From: Brereton, Steven [Steven.Brereton@lancashire.gov.uk]
Sent: 28 June 2013 12:45
To: Jane Tucker
Cc: Graeme Thorpe; Lorimer, Elliott
Subject: RE: Consultation on planning application 3/2013/0357 land north of Huntroyde Home Farm, Huntroyde West, Whins Lane, Simonstone.

Regarding the above application I make the following comments:

Documents Submitted in Support of the Application

N160: Huntroyde
Cumulative ZTV; 60.7m to Blade
Tip & Additional Proposed
Turbines
N160-GR-LVIA-011
As Shown @ A3
February 2013

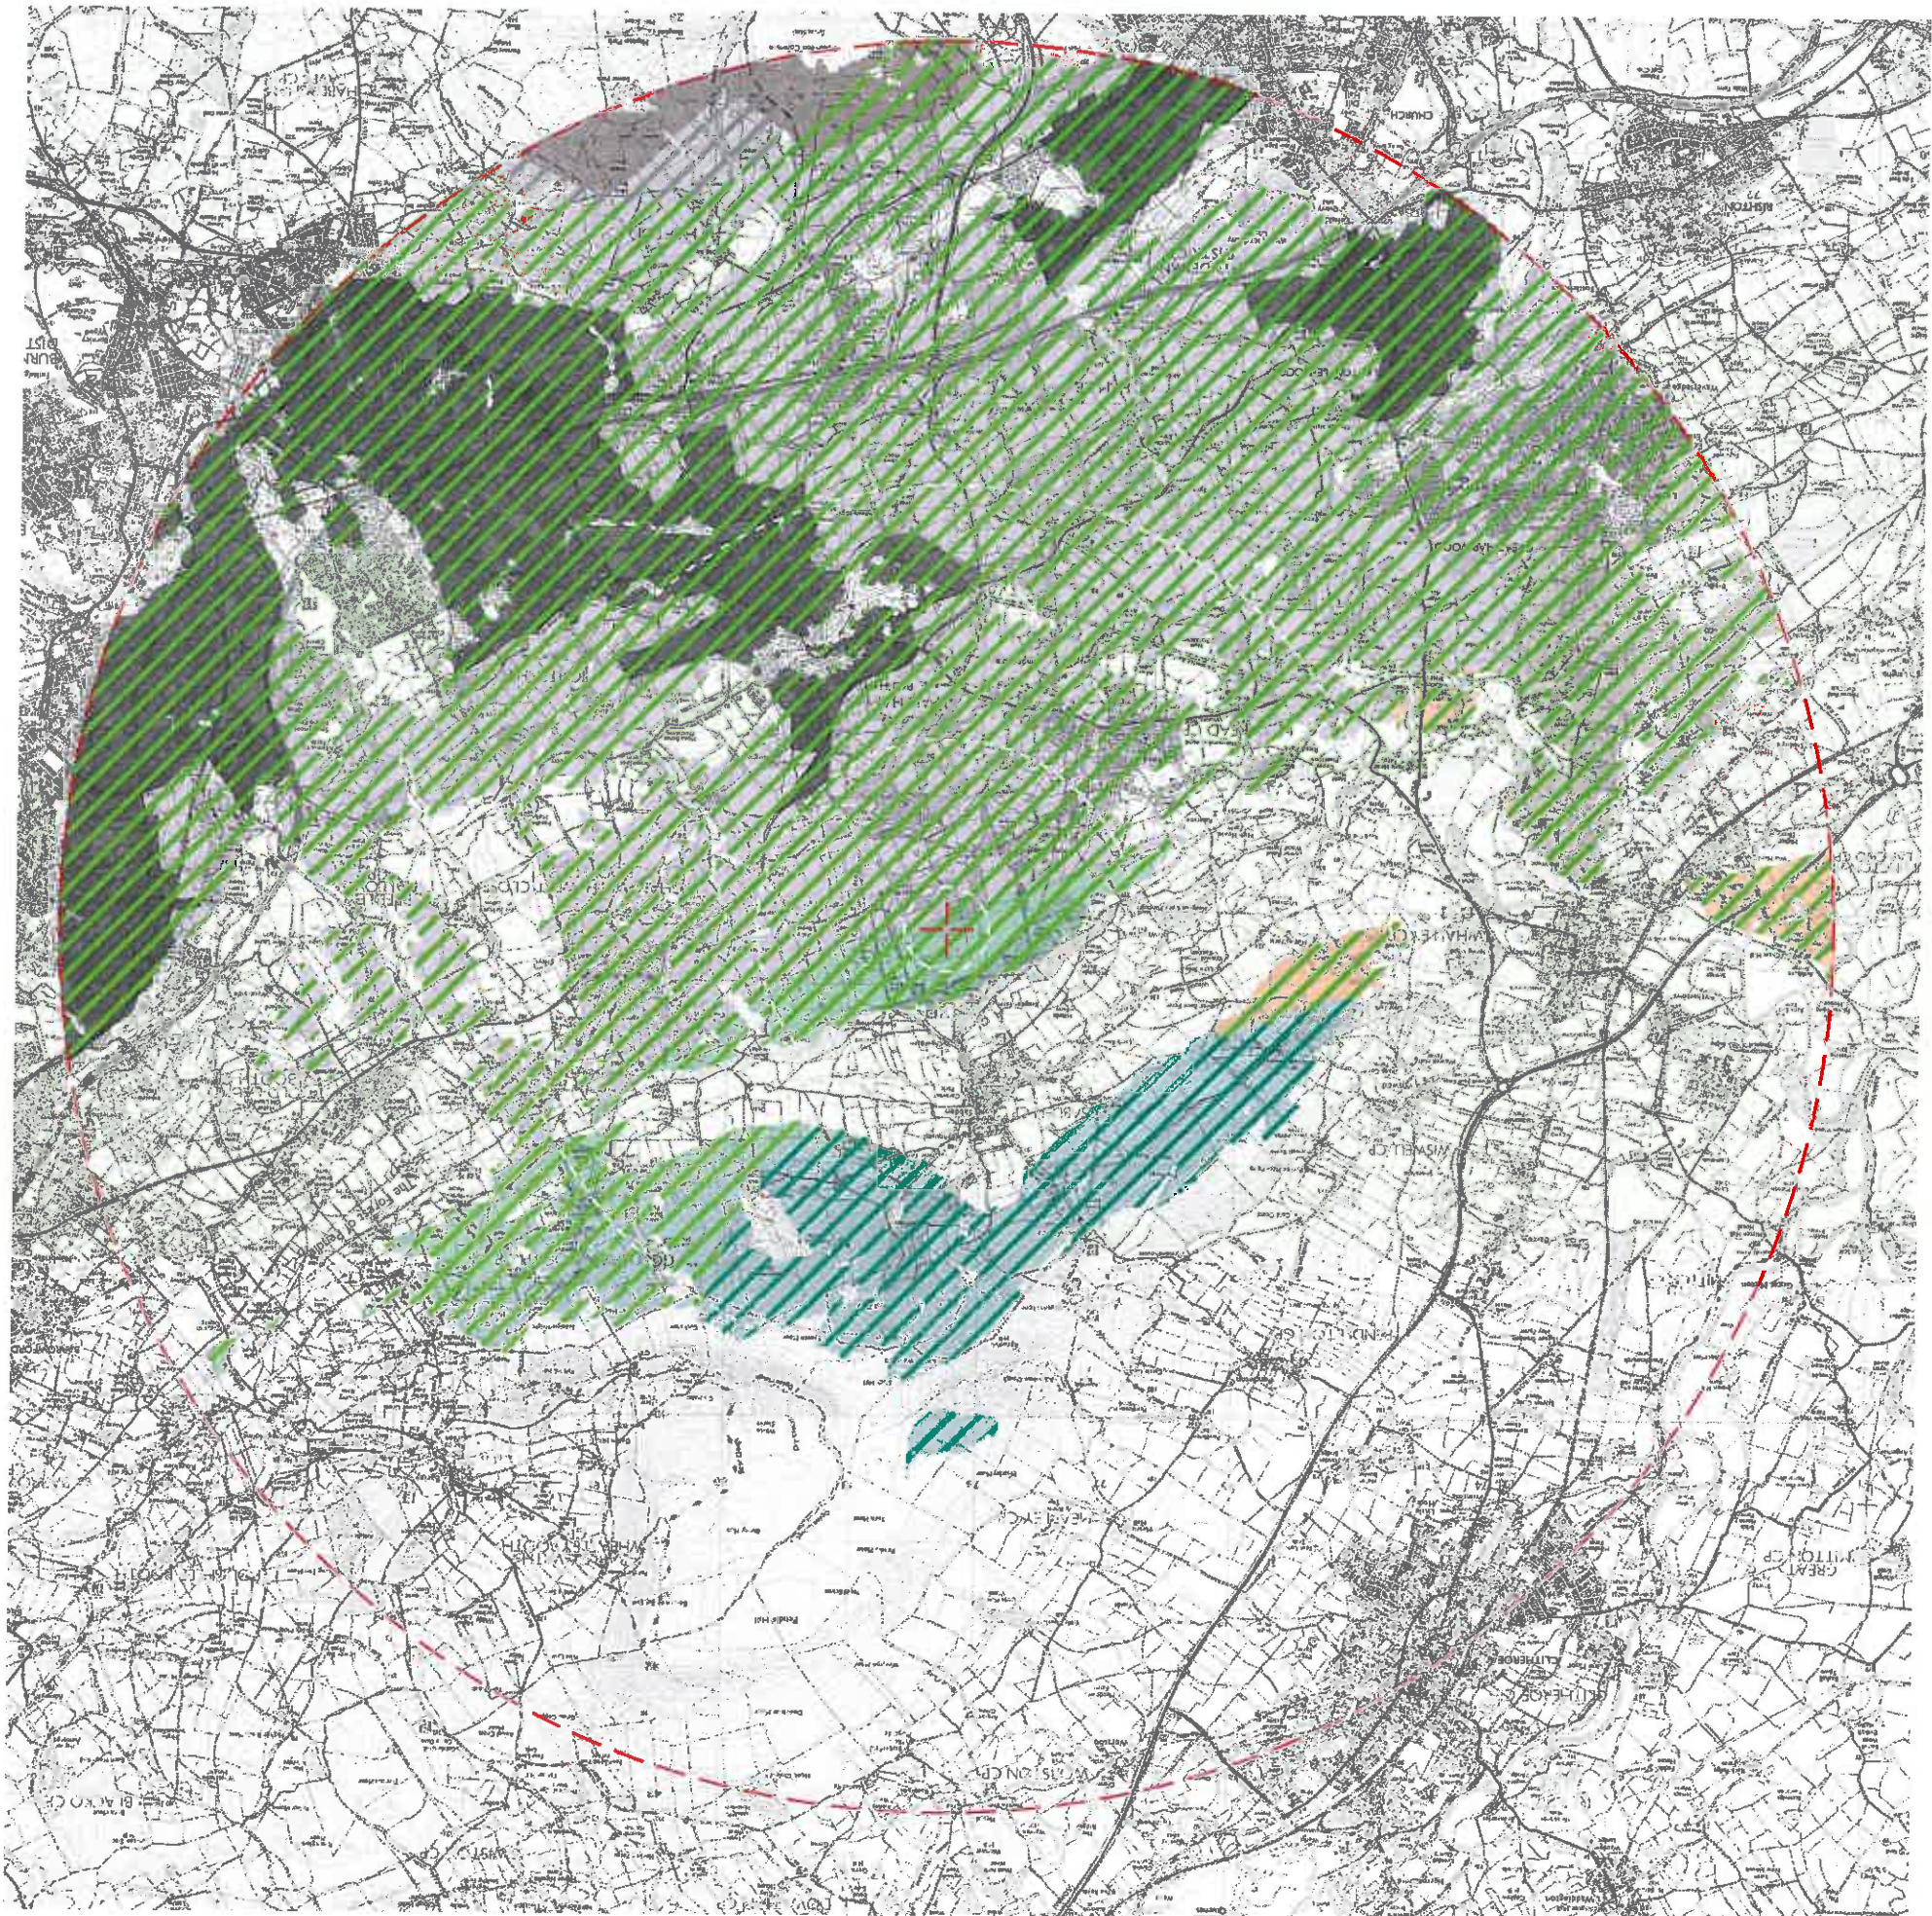
A description of the methodology used to produce the ZTV maps should be provided. In addition the applicant has used a gradation for the shading on the ZTV maps to depict areas of theoretical visibility and show that the magnitude of visual impact is mitigated by distance. This is very misleading because it cannot be assumed that there is a direct relationship between distance and relative visibility or magnitude of visual impact.

project title
figure title
figure reference
scale
date
N160: Huntroyde
Viewpoint 1: Trapp Lane, Whittle Hill
N160-GR-LVIA-013
1:25,000 @ A3
February 2013

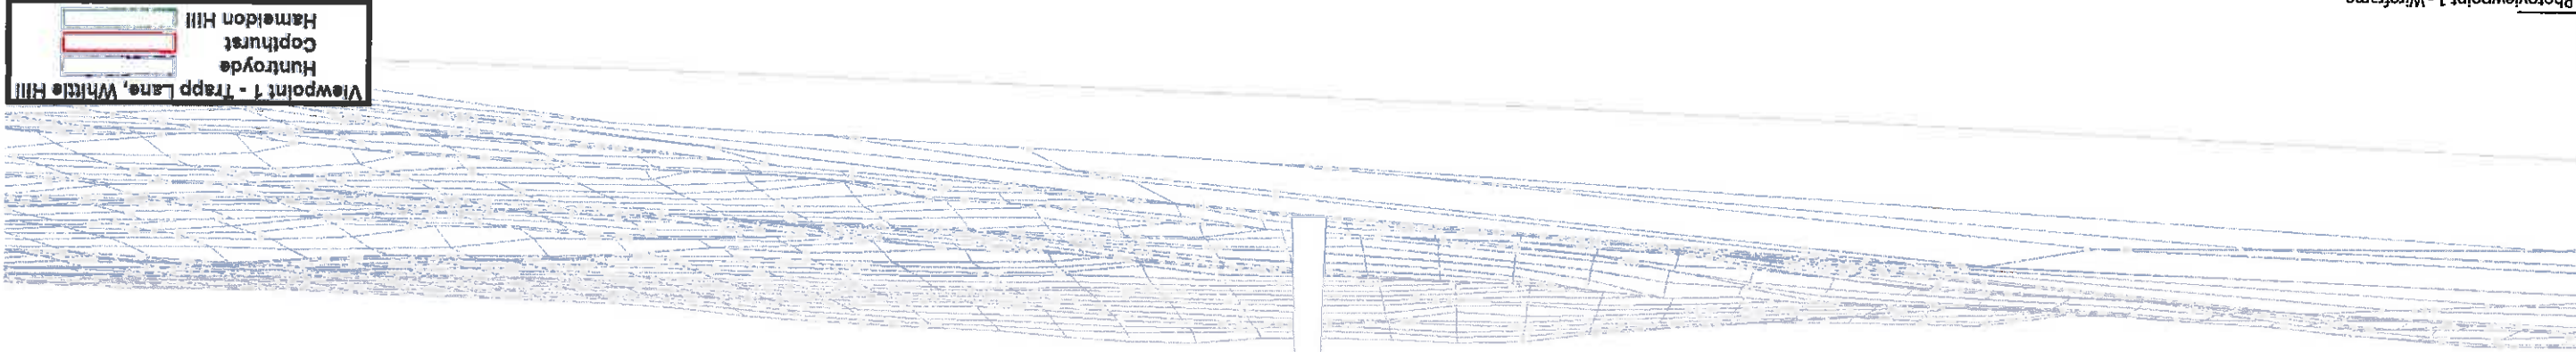
Viewpoint 1 is of little use as only the very tip of a turbine blade would be visible; information easily gleaned from the ZTV maps and topographical data. In viewpoint 2 the wind turbine is partly obscured by trees and in viewpoint 4 the turbine could not be seen.
